Jean Fraser - 133 York St

**From:** Erin Foley <efoley19@aol.com>  
**To:** Jean Fraser <JF@portlandmaine.gov>  
**Date:** 10/22/2013 4:47 PM  
**Subject:** 133 York St

As far as the project at 133 York Street I would like to bring up the following concerns:

SITE PLAN MAP 44/BLOCK A/LOTS 29 & 31

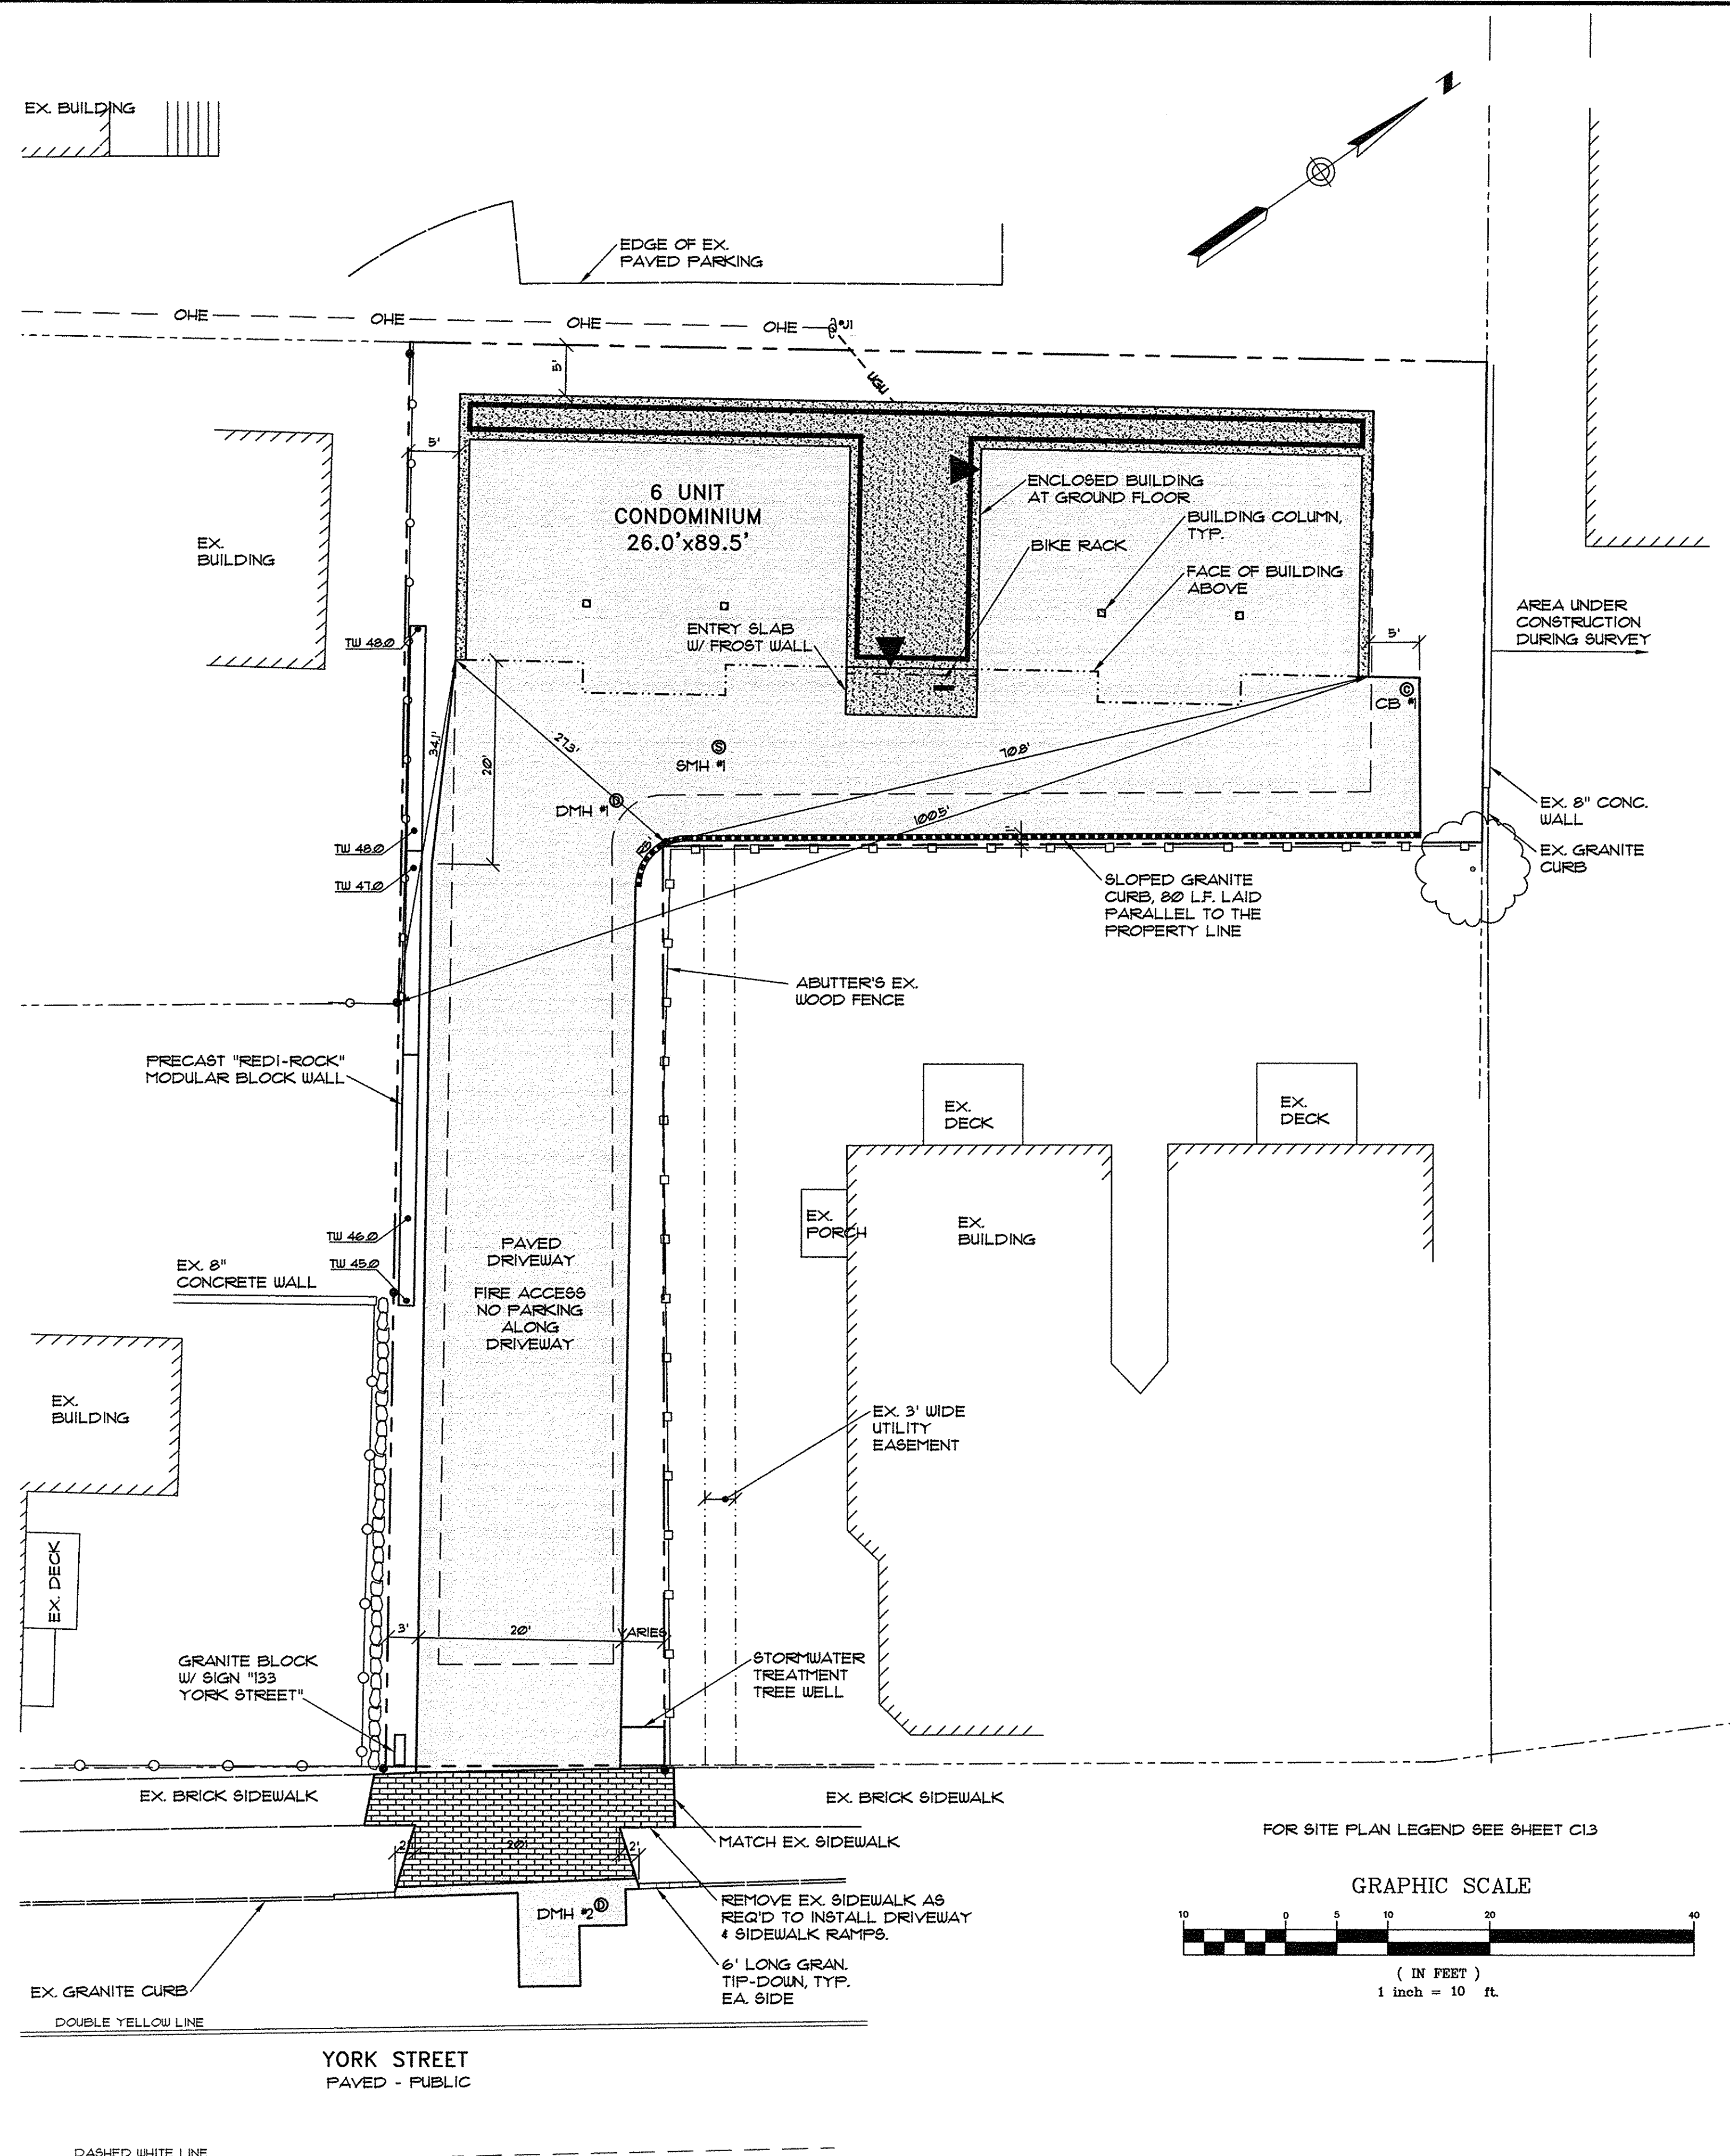
6. The city requires space for delivery trucks to deliver and turn around on the property. I do not believe there is enough space for delivery trucks to turn around. This leaves trucks backing up onto York Street or worse parking on the side of York Street.

7. Along the lines of turning radius, how will a snow plow be able to move and remove snow from this property?

8. We are concerned about the electrical lines that run to this property. Is there any plan to update the electrical lines or bury them? Currently they run from the opposite side of Park St through multiple trees to a telephone pole. From the pole they precariously run to the building. 3. Availability and adequate Capacity of public utilities. b. Electrical services shall be underground unless otherwise specified for industrial uses, or if it is determined to be unfeasible due to extreme cost.

EROSION CONTROL AND LANDSCAPE PLAN

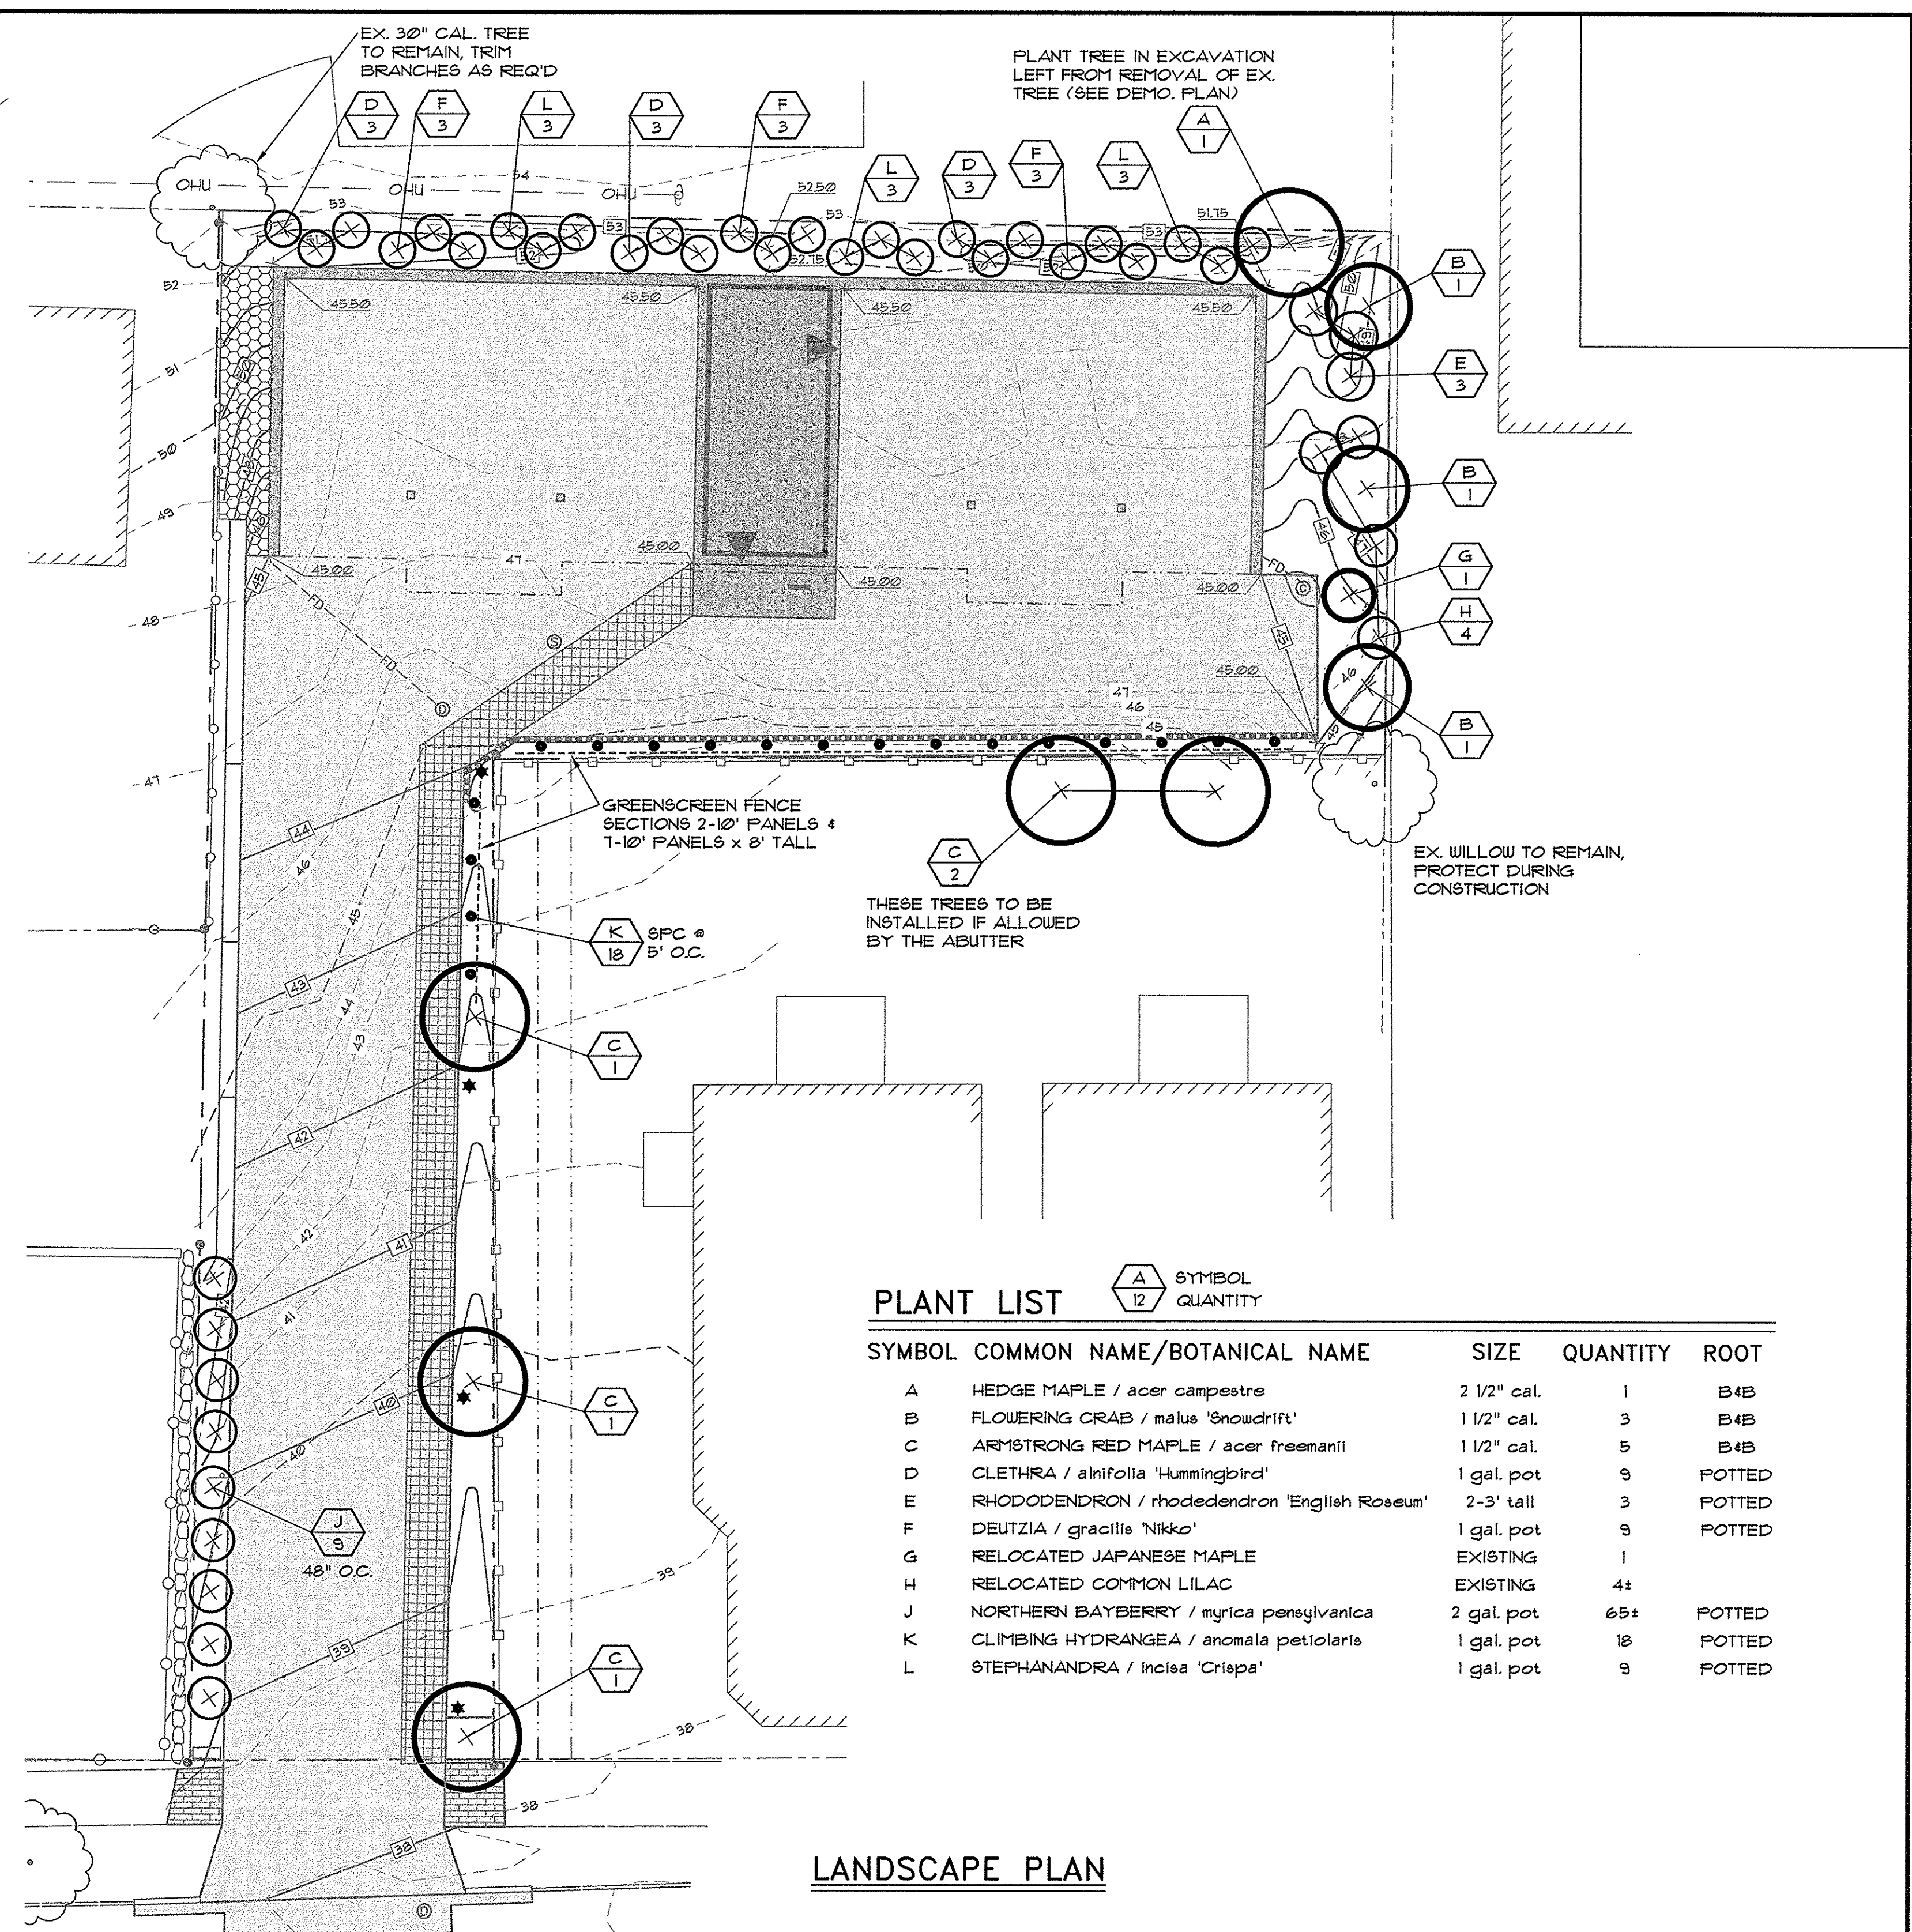
1. The trees. Multiple trees stand on the property line. I would like to see an official landscape survey to see all trees on the property and determine ownership. If trees are shared, will the developers be required to replace them on our property if they are removed.

5. The rear of the building has no privacy from our property, a few trees but no real plan for landscaping the rear of the building. Is there a possibility for a fence or shrubbery to provide a separation of the properties.
